Consultation Response from KC, Conservation & Design
2022/92459 Bankgate Mills, Bank Gate, Slaithwaite, Huddersfield, HD7 5DL
Conversion of former mill to form 5 apartments including extension and alterations, erection of 2 detached dwellings and demolition of outbuilding
Date Responded: 2.3.2023
Responding Officer: Sue Brooks
Responding Ref: CV 5/16

Following the previous Conservation and Design response dated 28 November 2022, amendments have been submitted. The comments below are in response to these amendments.

Proposed East Elevation - 1:100

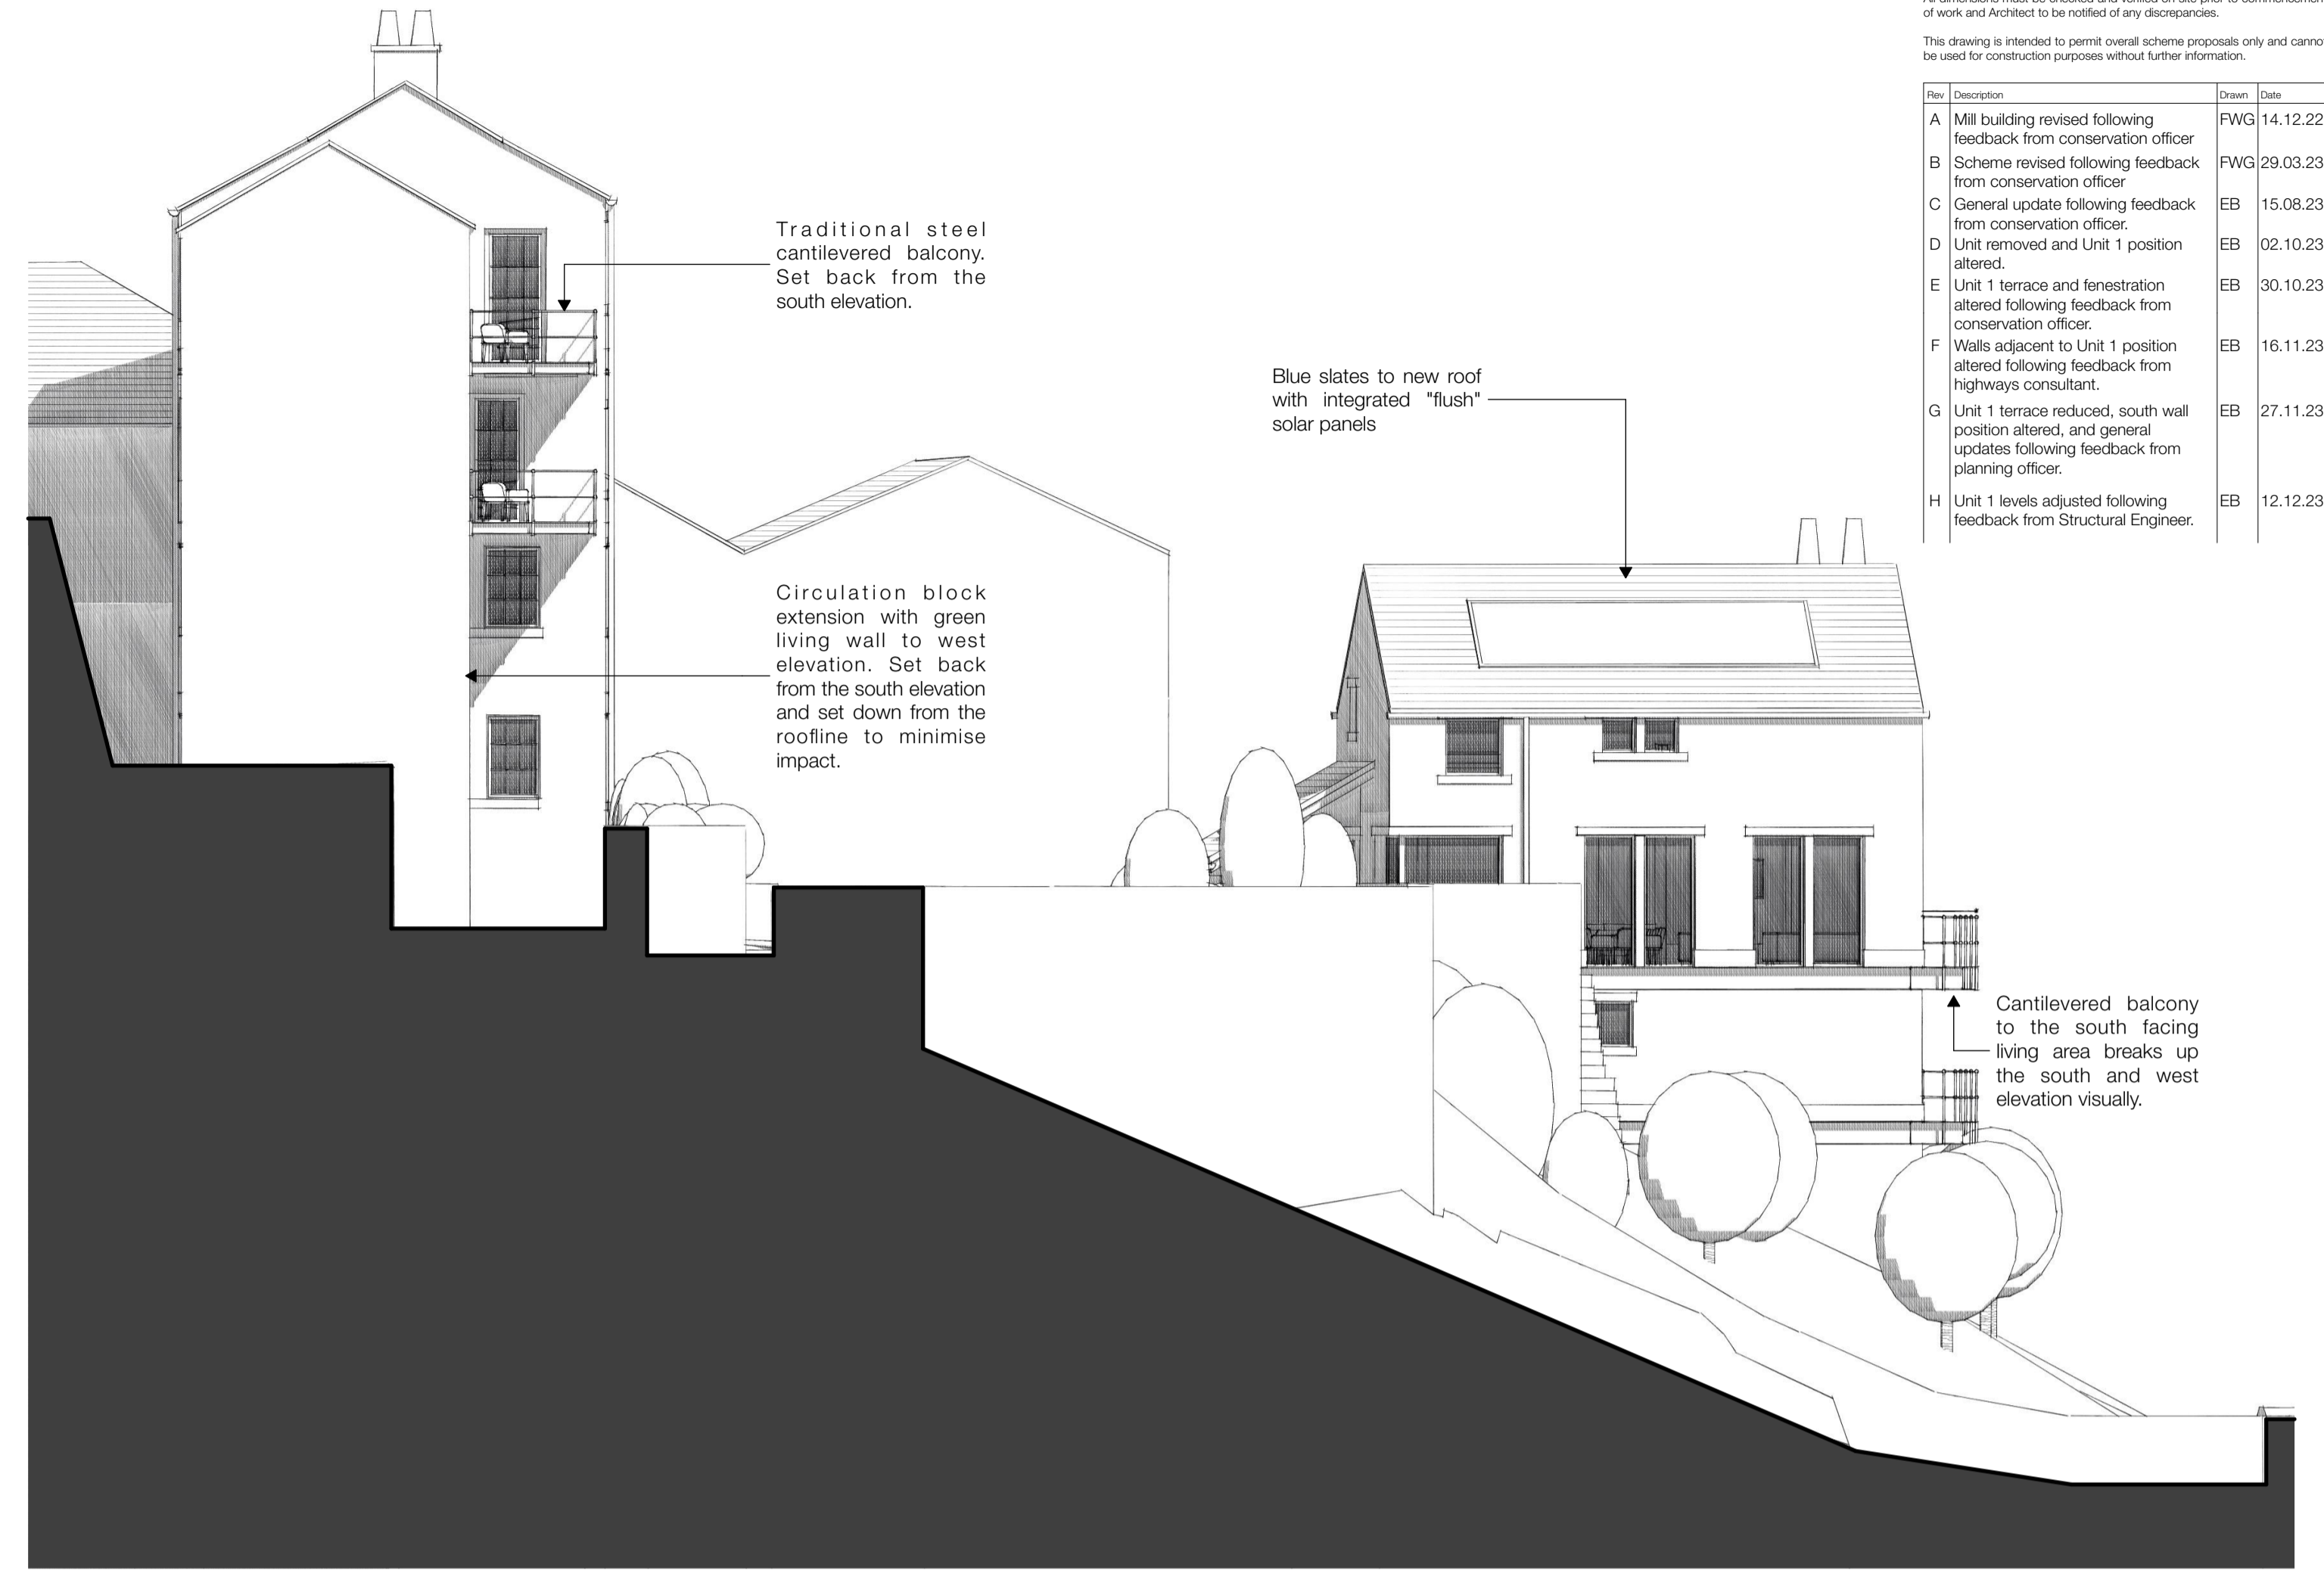
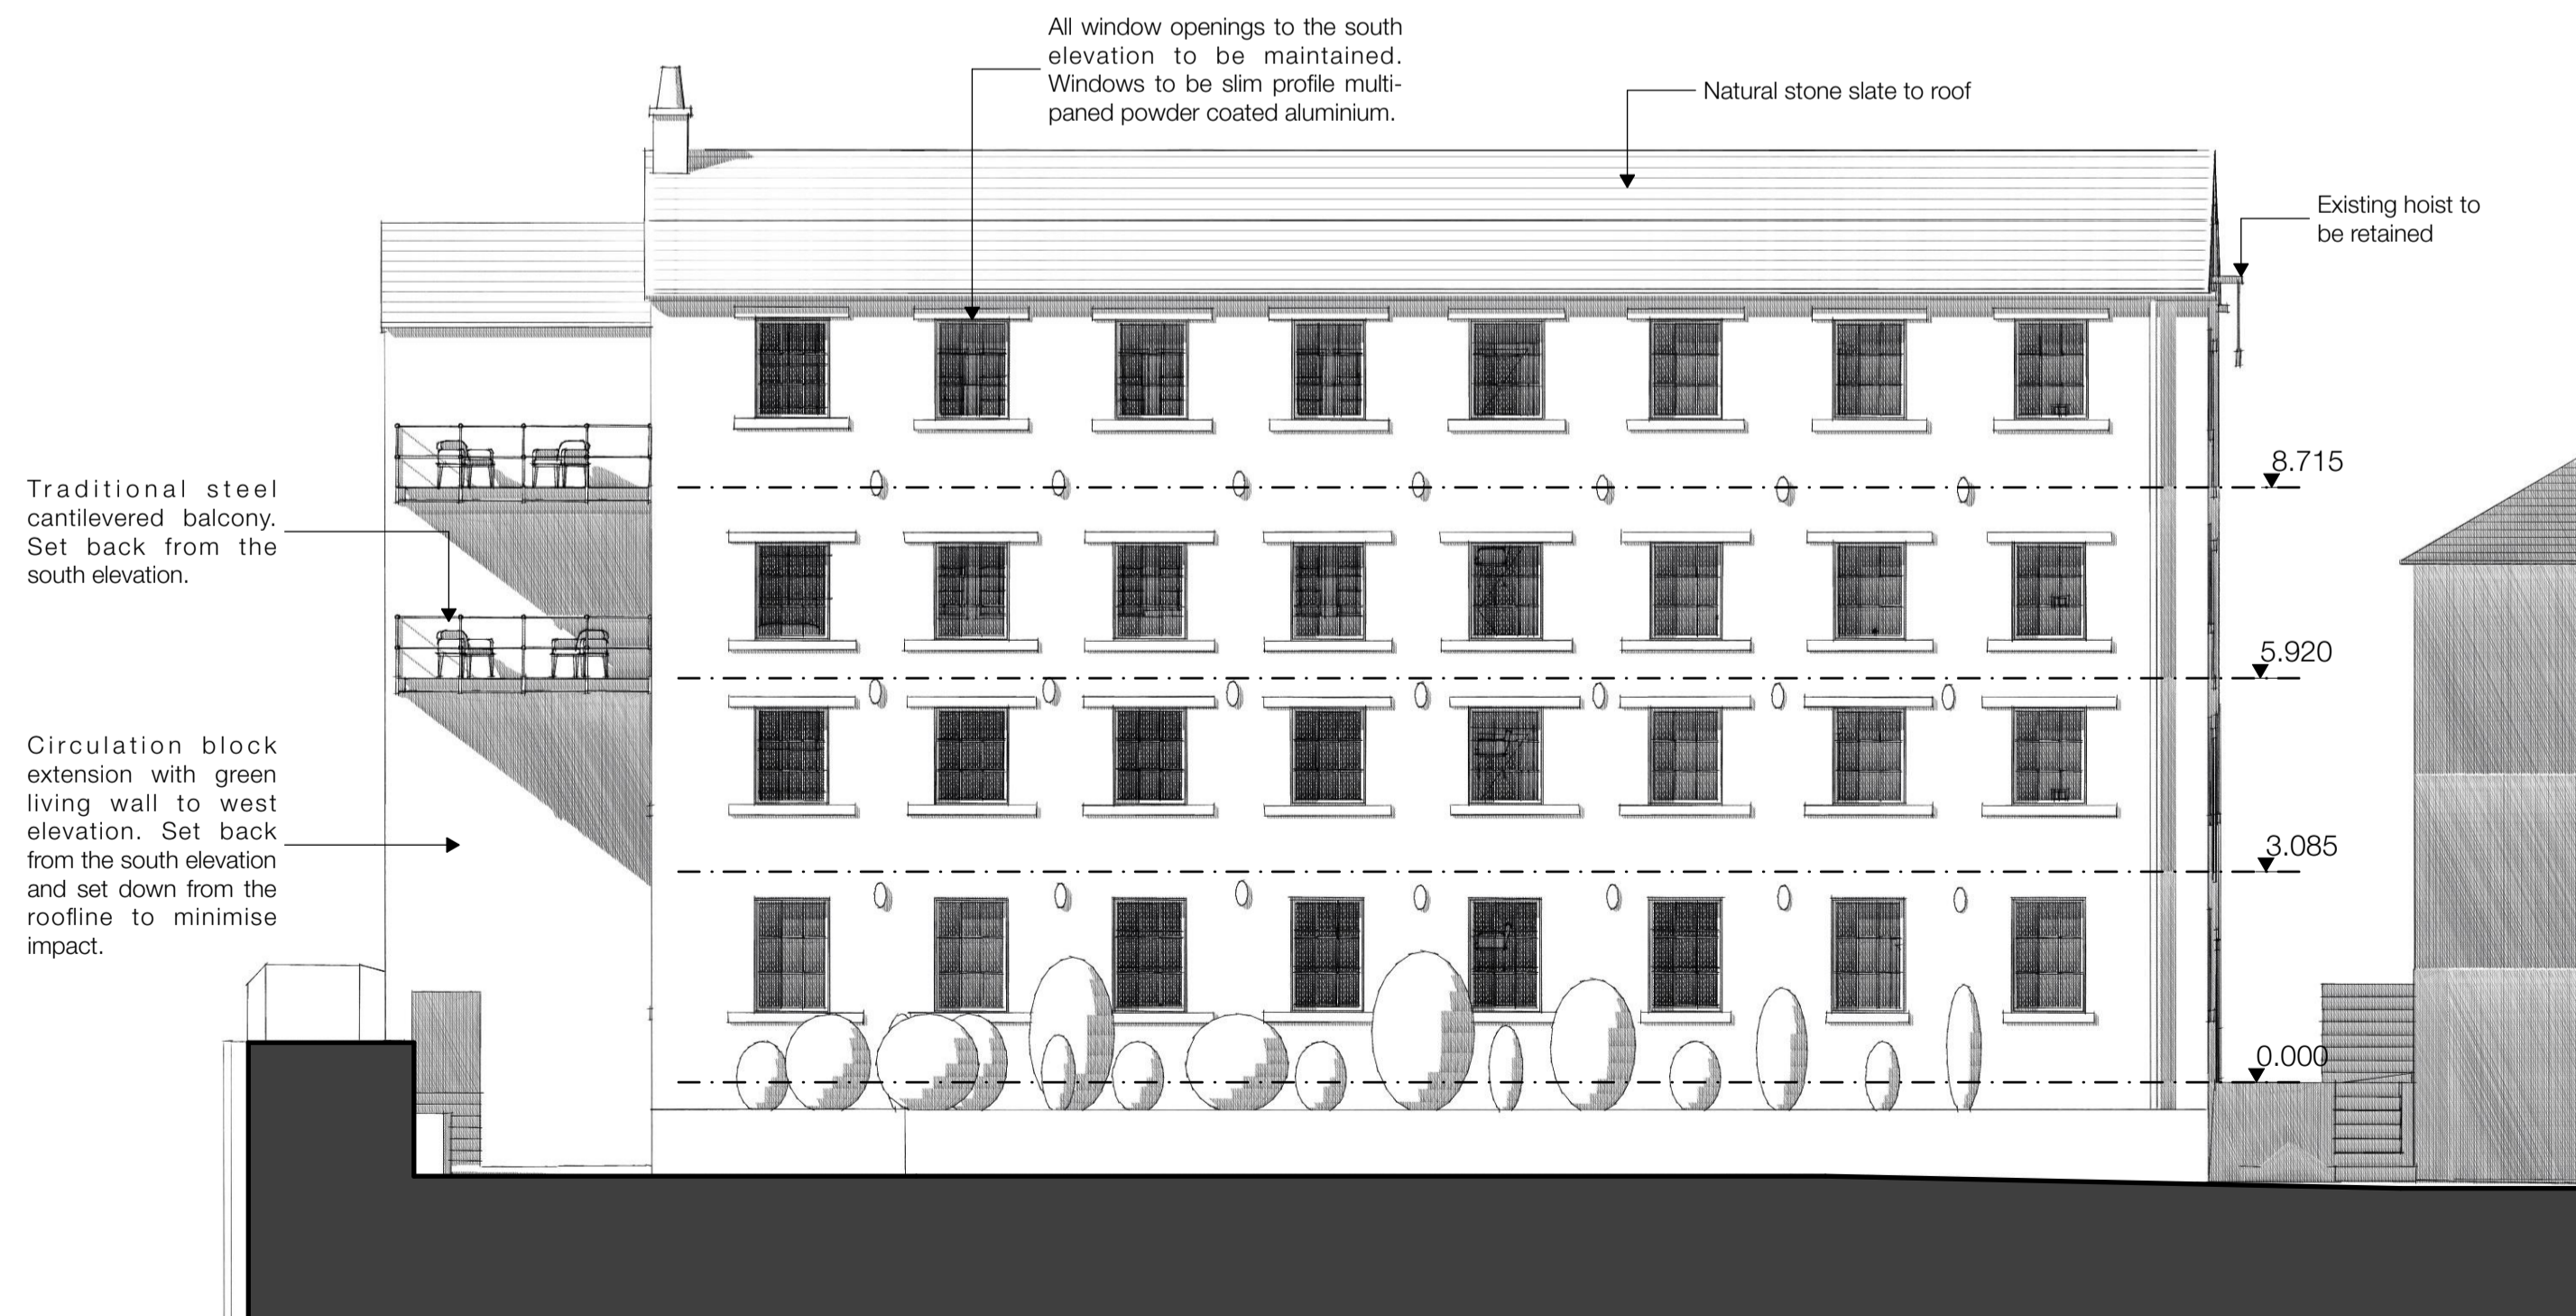
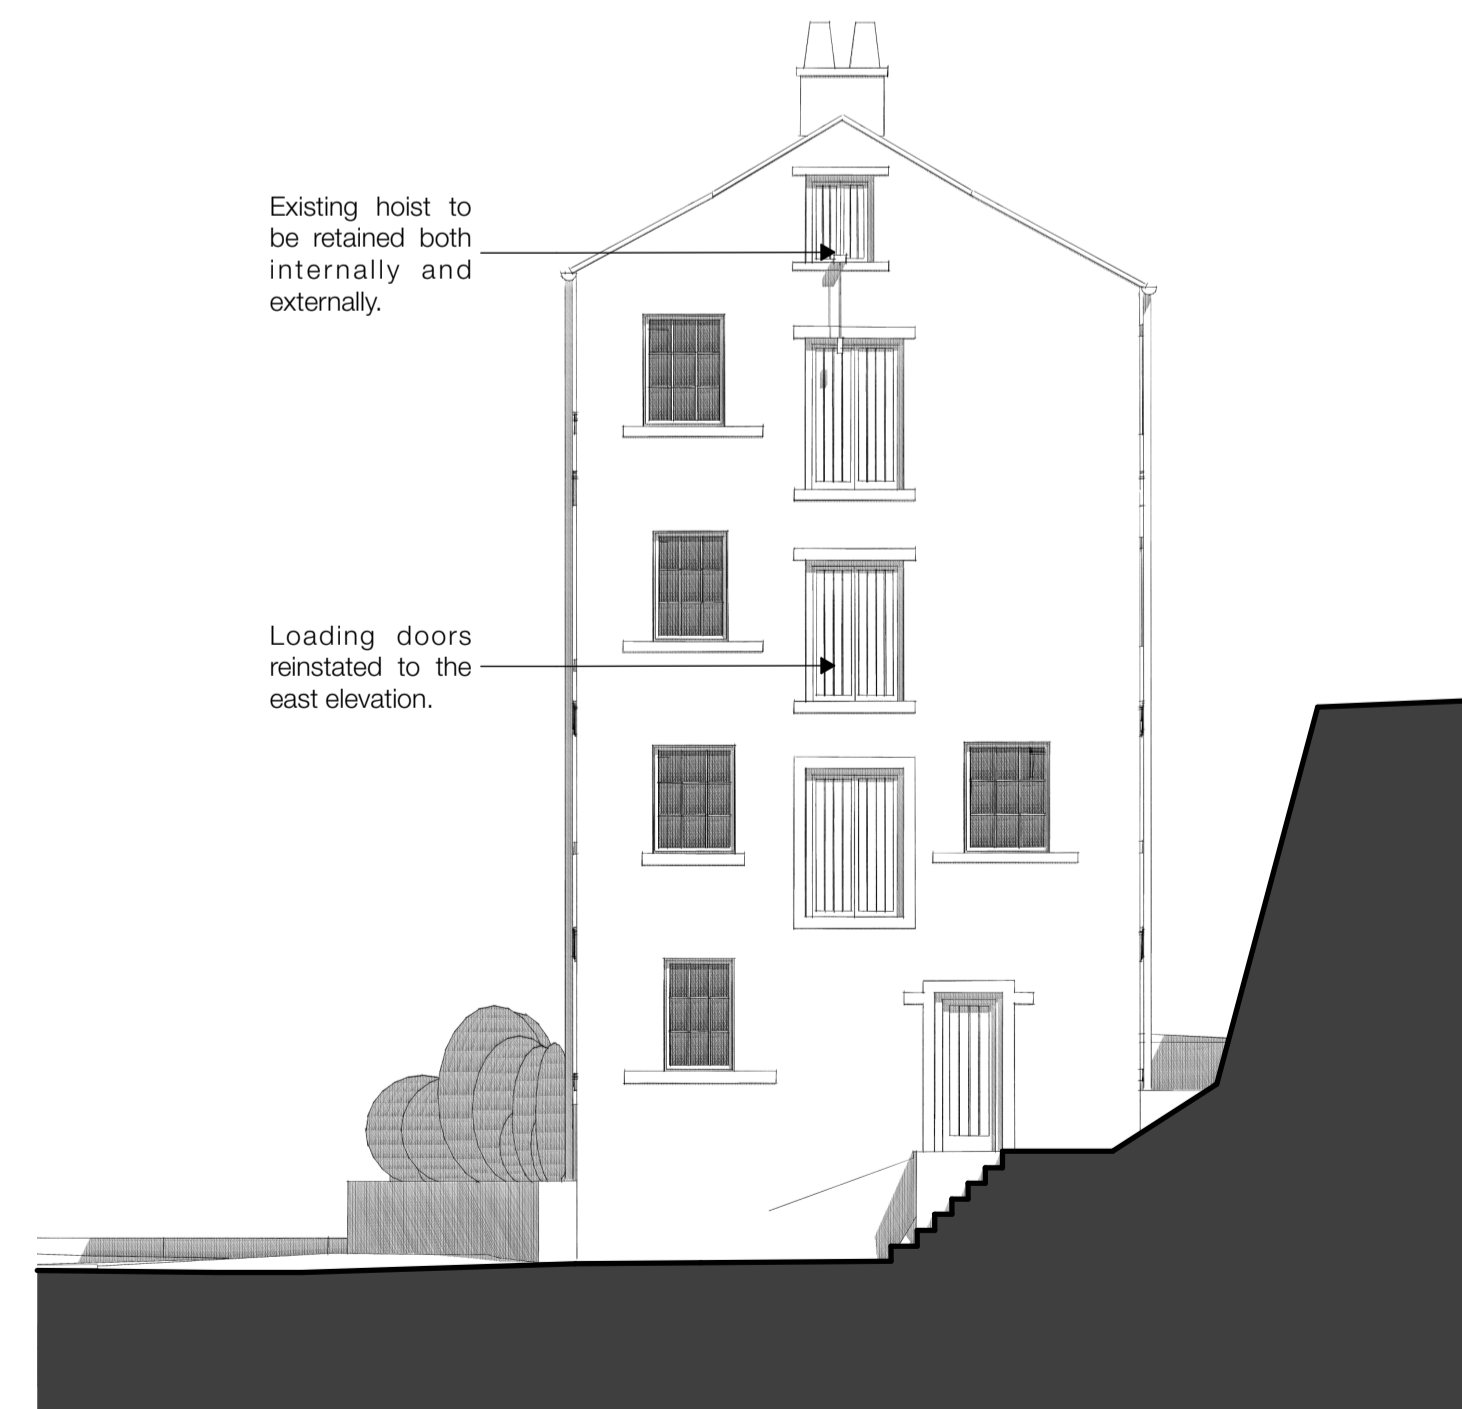
Proposed windows are shown on the elevation drawings but no details have been submitted. Following our previous response, the applicant has clarified that slim aluminium framed, multi-paned windows are proposed in the same configuration as the surviving historic timber framed windows to retain the industrial character of the building. We accept the change in material from timber to aluminium with the same profiles and design as maintenance is likely to be difficult at high level and the building is in an exposed location. As most of the historic windows are missing, slim double-glazed units would be acceptable subject to detailing and can be submitted by condition. **If the application is supported full details need to be submitted for approval, including 1:20 elevations and 1:5 sections showing opening lights, profiles, depth within the reveals, glazing, colour and materials.**

In the revised drawing, loading doors are shown on the east elevation and this enhances the character and significance of the building. The historic hoist on the gable is retained both internally and externally. **If the application is supported proposed details of the doors need to be submitted for approval, including 1:20 elevations and 1:5 sections showing design, depth within the reveals, glazing, colour and materials.**

Cantilevered balconies were originally proposed on the south and west elevation, wrapping around the corner of the building and partially obscuring the architectural interest of the south elevation. This has been amended, with the balconies now located on the west elevation and set back from the south elevation, wrapping around the circulation tower. To access them, two window cills will be lowered to create doorways onto these structures. We are not convinced that these balconies respect the architectural style and significance of the former mill, and as they are highly visible we would not agree that they are subservient to the main building. The level of details submitted with the application is

limited, including structural details, materials and finish. Based on the information submitted, we are still unable to support this element of the proposal.

A circulation tower is proposed on the west gable, set back from the façade and with a flat roof at eaves level and with a green living wall. We accept the introduction of this structure to maximise useable floorspace within the building and would recommend that construction details and materials are submitted if the application is supported. We have concerns about the future maintenance of the proposed green wall and need to be convinced that this will remain a positive feature. Consideration to an alternative finish could be considered.
